Subject: Response To Application Number FP/258/19/PL at 107 Felpham WayBognor RegisPO22 8QB

WEST SUSSEX COUNTY COUNCIL CONSULTATION

TO:	Arun District Council FAO: Ms M Tomalova
FROM:	WSSC - Highways Authority
DATE:	28 January 2020
LOCATION:	107 Felpham Way, Bognor Regis, PO22 8QB
SUBJECT:	FP/258/19/PL Conversion, alteration & extension to provide 1 No. Class A1 Shop Unit, 1 No. Flexible Use Commercial Unit Use Classes A1/A2/B1/B8/D1 or Sui-Generis Beauty Therapist/Nail Bar & 3 No. Flats together with 3 No. vehicle parking spaces & secure cycle & refuse storage facilities (resubmission following FP/32/19/PL).
RECOMMENDATION:	Modification

Vehicular Access Overview

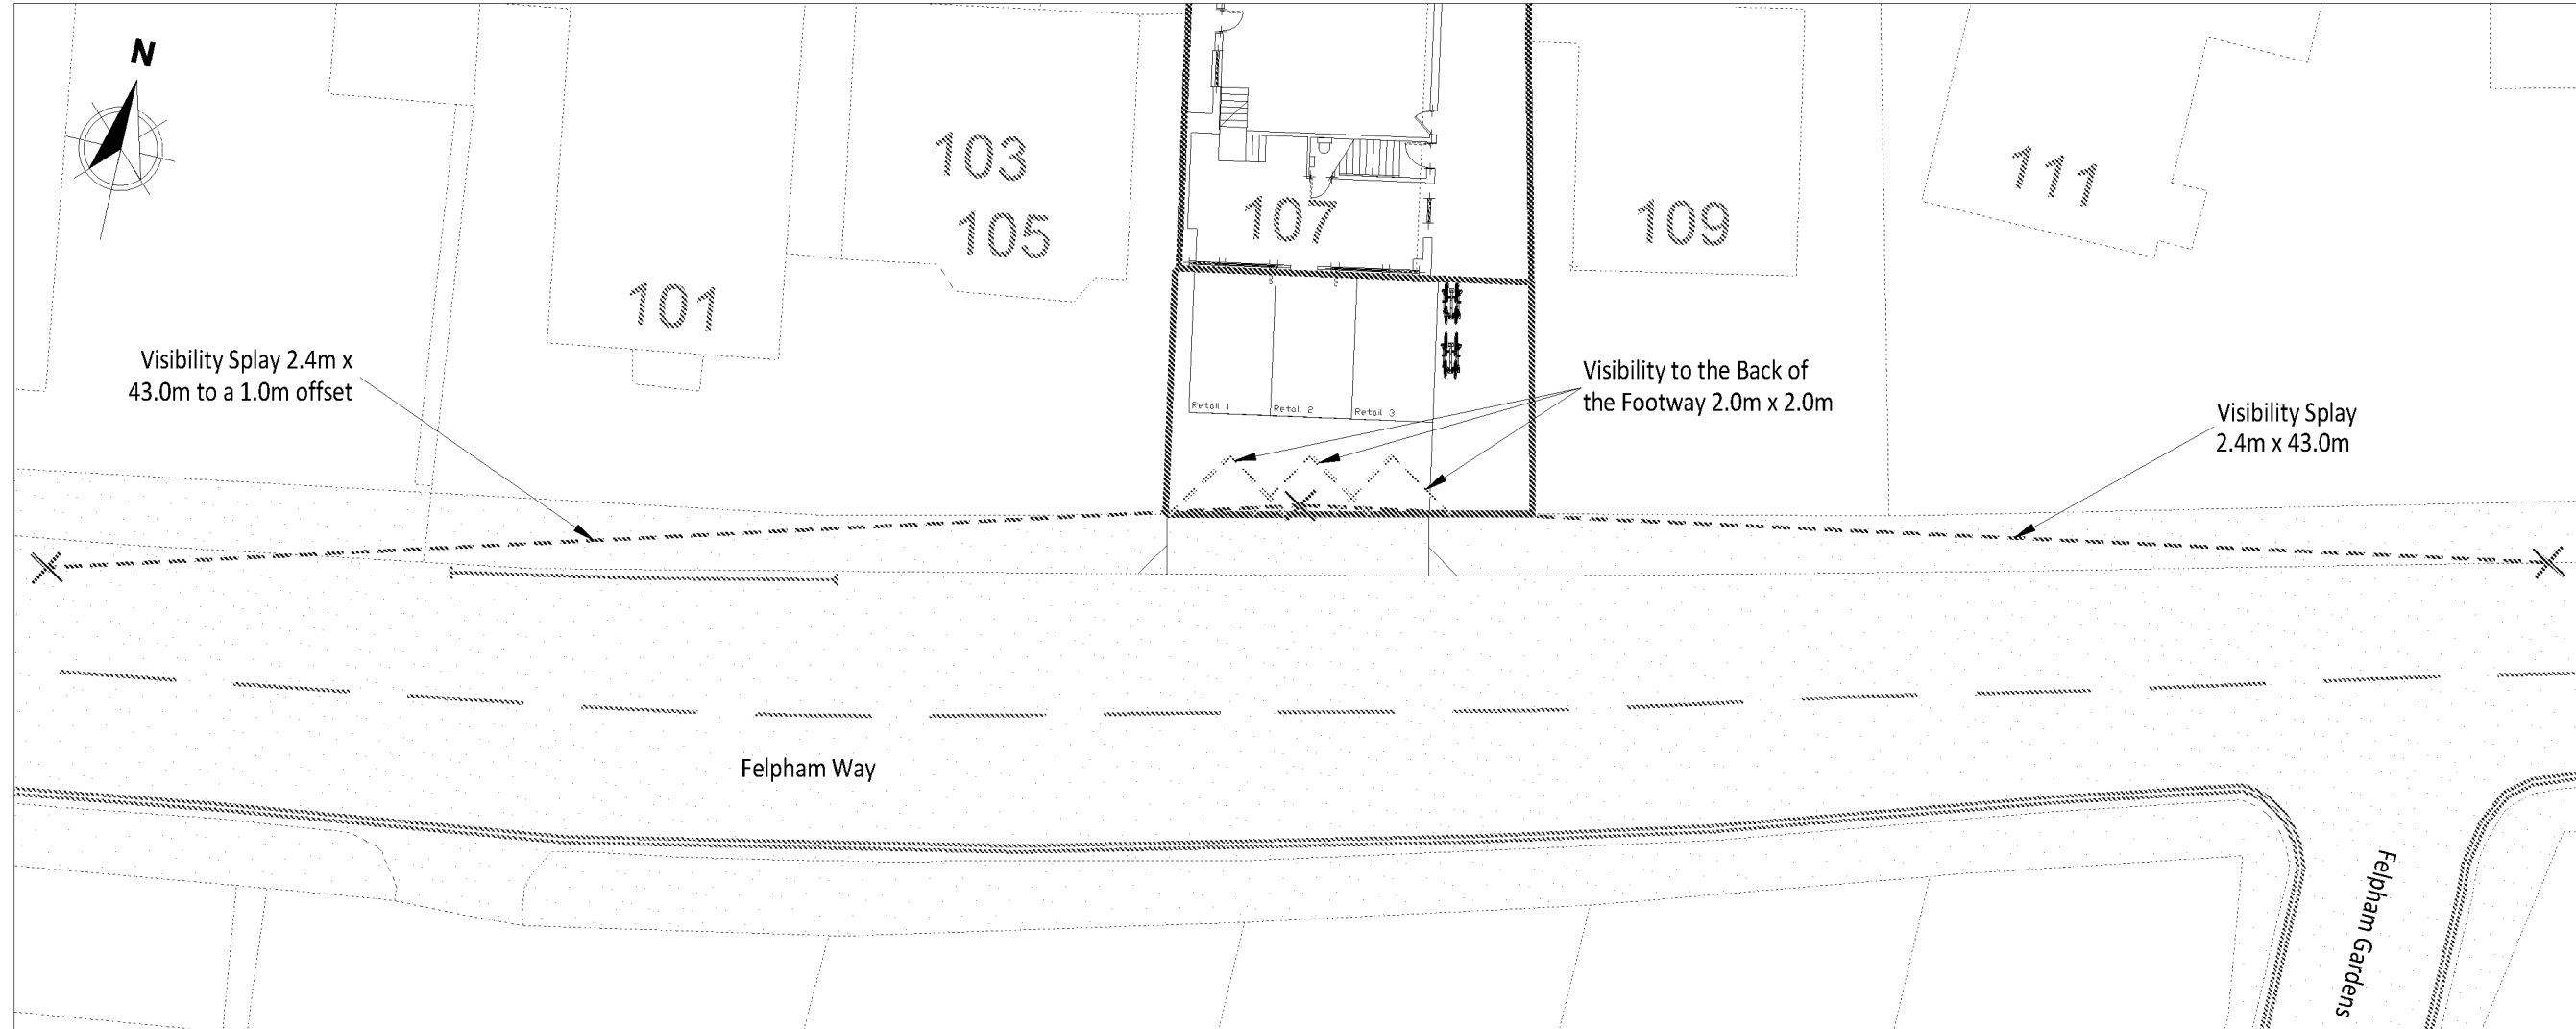
Swept path tracking diagrams within the TS demonstrate that a car can independently access each space. Nevertheless, the position of the parking spaces appears to block access to the A1 unit. The spaces should be repositioned and applicant should consider whether space fronting existing dropped kerb could also be used.

Ground Floor Plan - Proposed 1:100

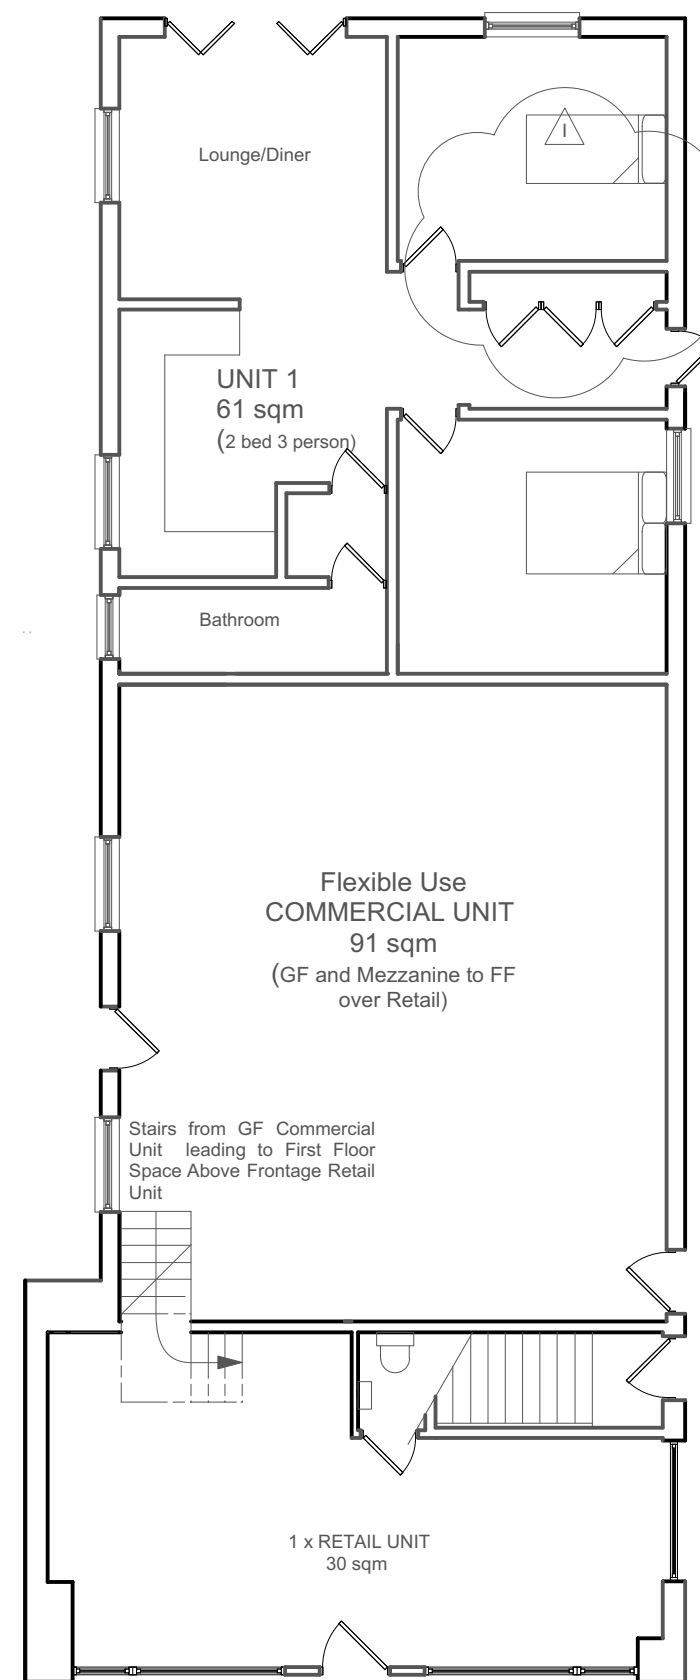
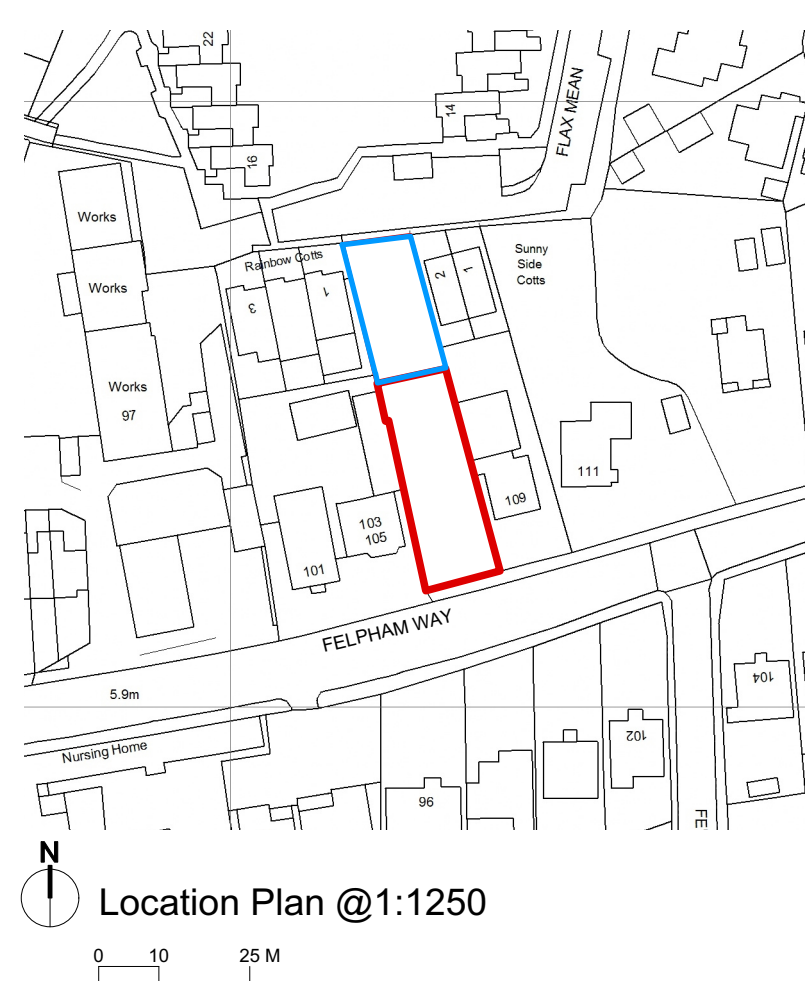
The plans state that the existing kerb is already dropped however the TS states that a 9 metre vehicle crossover (VCO) is proposed (extension to existing 4 metre VCO). An inspection of local mapping indicates that this is the case and the existing dropped kerb would need to be extended across the site frontage to facilitate access to the proposed car parking spaces.

on A1 use only which would result in a requirement for 2 x spaces (both customer and staff). A bicycle store facility has been indicated on the frontage. The applicant may wish to consider relocating this, depending on how the car parking spaces are reoriented and space available for access.

In summary the principle of development is not anticipated to result in a highway safety or capacity issue, however the LHA require that the parking space locations are modified to make best use of the forecourt area and not block access to the units. The location and amount of bicycle parking should also be reviewed.
